Subject: RE: 0119: P/38/19/PL - Newlands Nursery - Year Round Retention of Seasonal Agricultural Workers Caravans

Dear Paul,

I write separately to my below message. I have a question regarding site ownership. On the location plan, you have only red edged the application site and there is no blue edging. Am I therefore correct in assuming that your clients do not own any other parts of Newlands Nursery? Your Design and Access Statement states that the applicants are part of a parent group that also owns Newlands Nursery...

Site Location Plan
PROPOSED
Feb 2019
0119-001 B
1:2500@A3

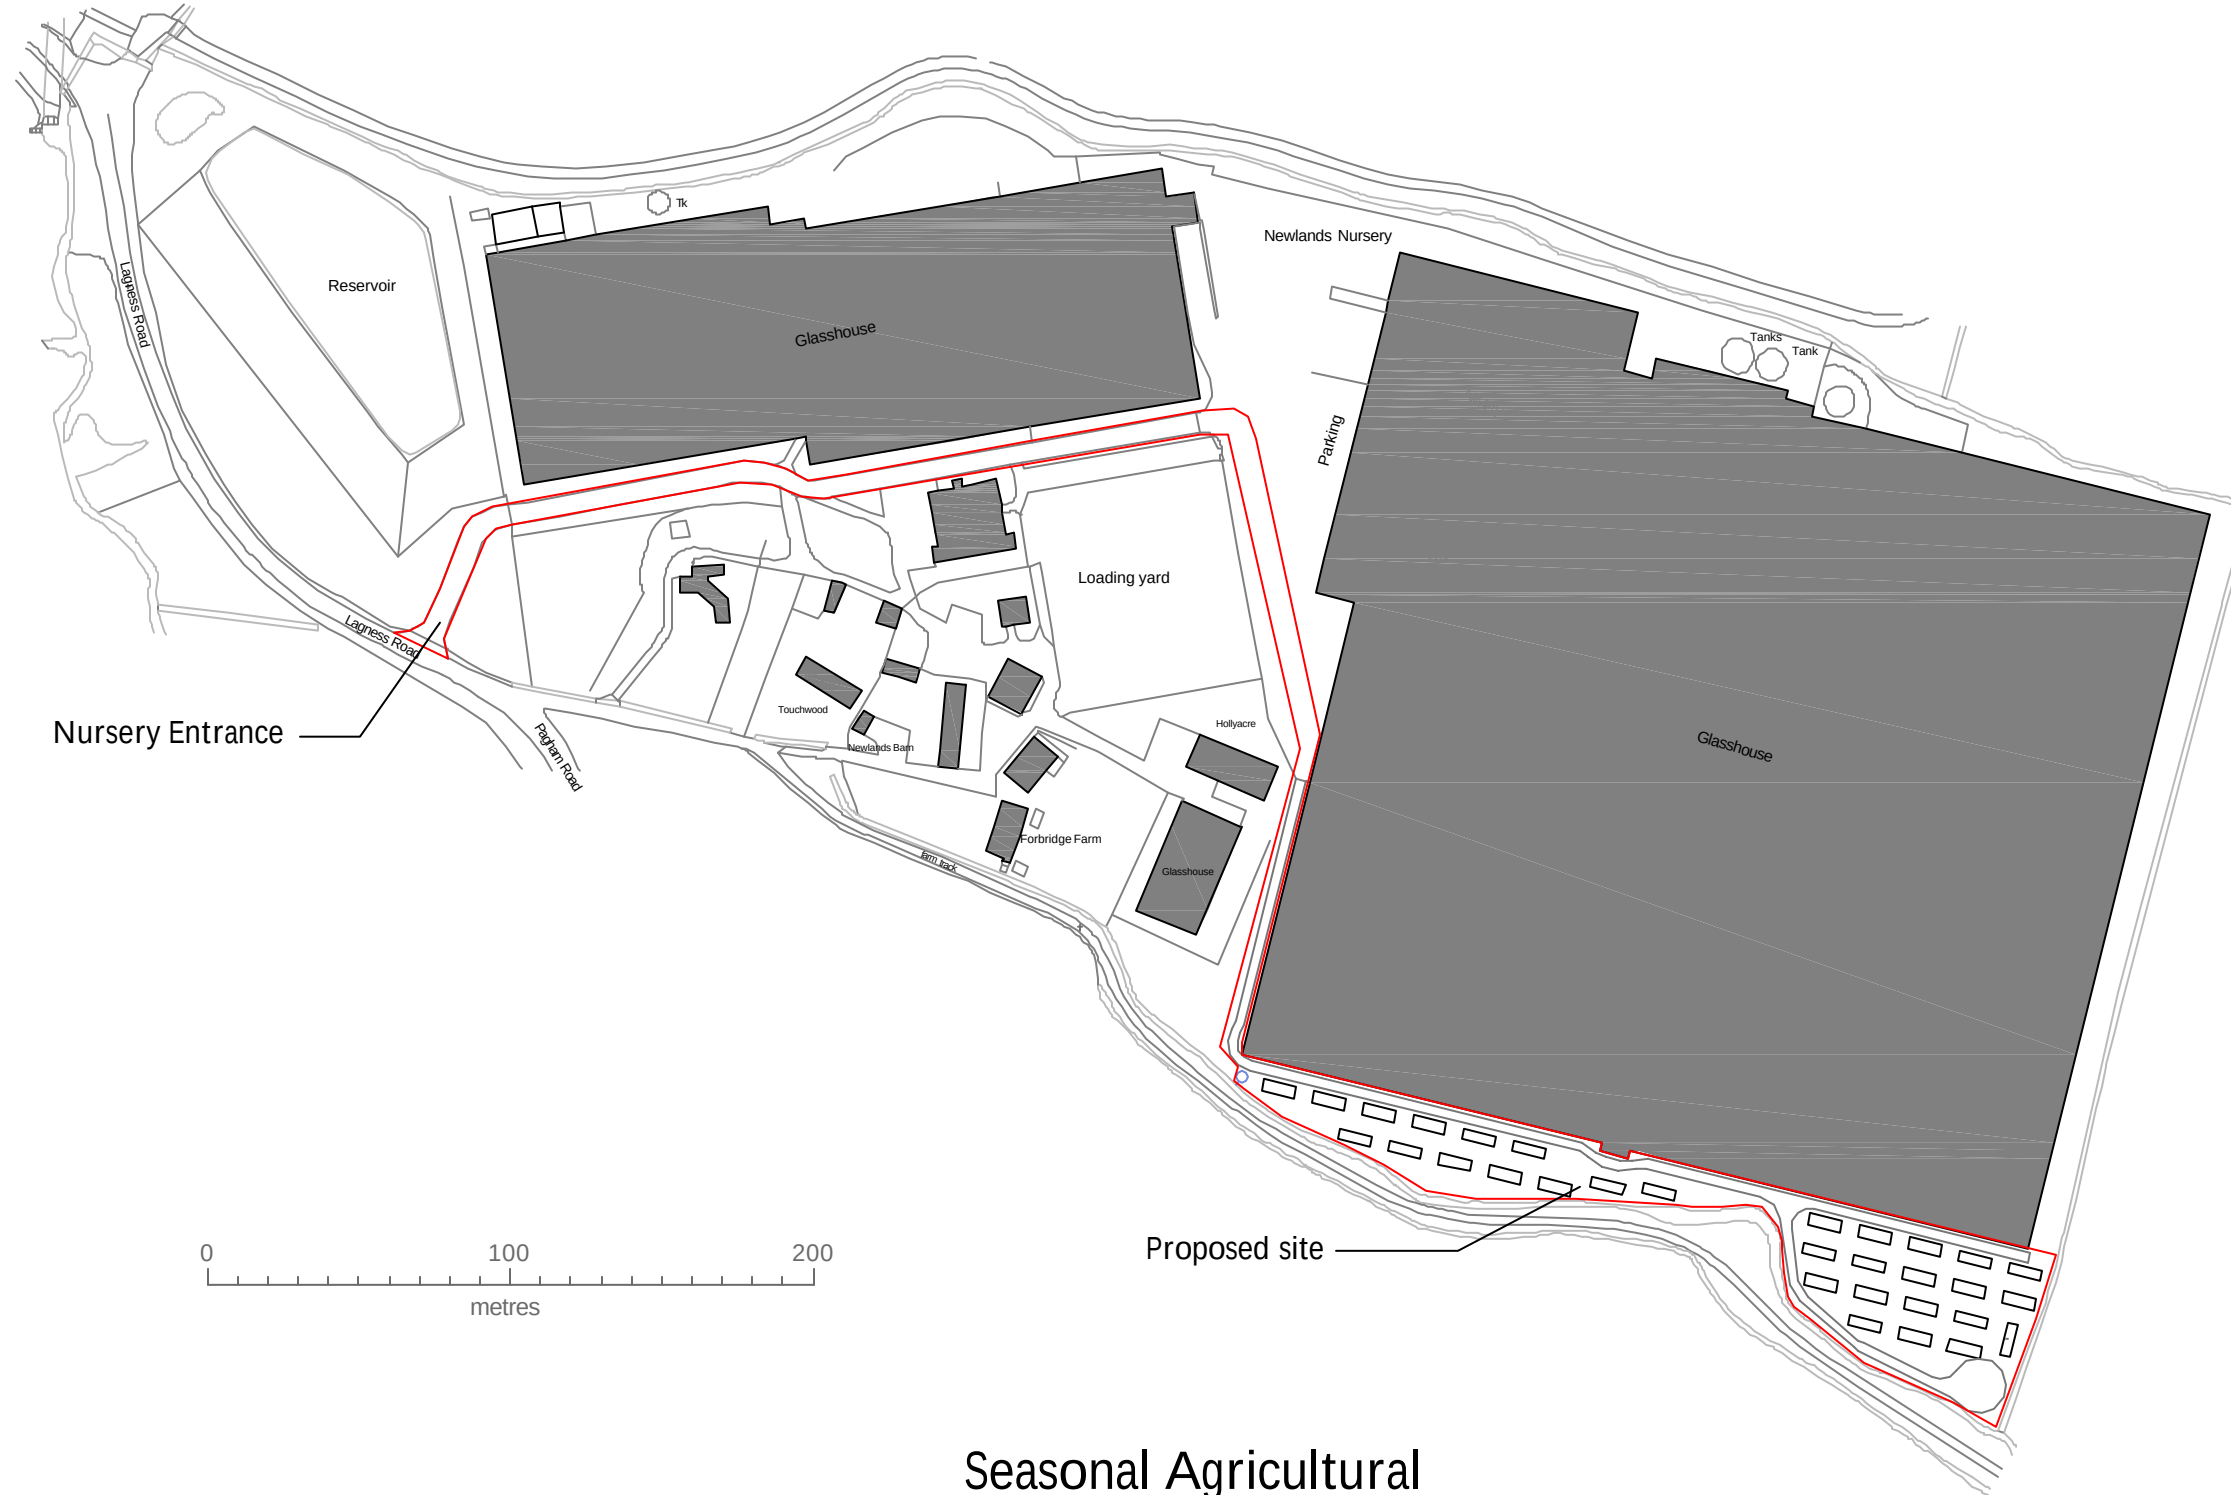
Furthermore, your red edge on the location plan does not include the access to the highway. I believe this has caused some confusion with residents who think that you will be accessing the site from the private track. The proposed access track which runs around the SW corner of the glasshouses is not clear on the submitted layout plan. It would be helpful if you could amend the submitted red edge to show the access all the way to the highway. We can accept this as an amendment and will not need to reconsult on the changes. However, you may need to serve notice on any other owners of the access route.
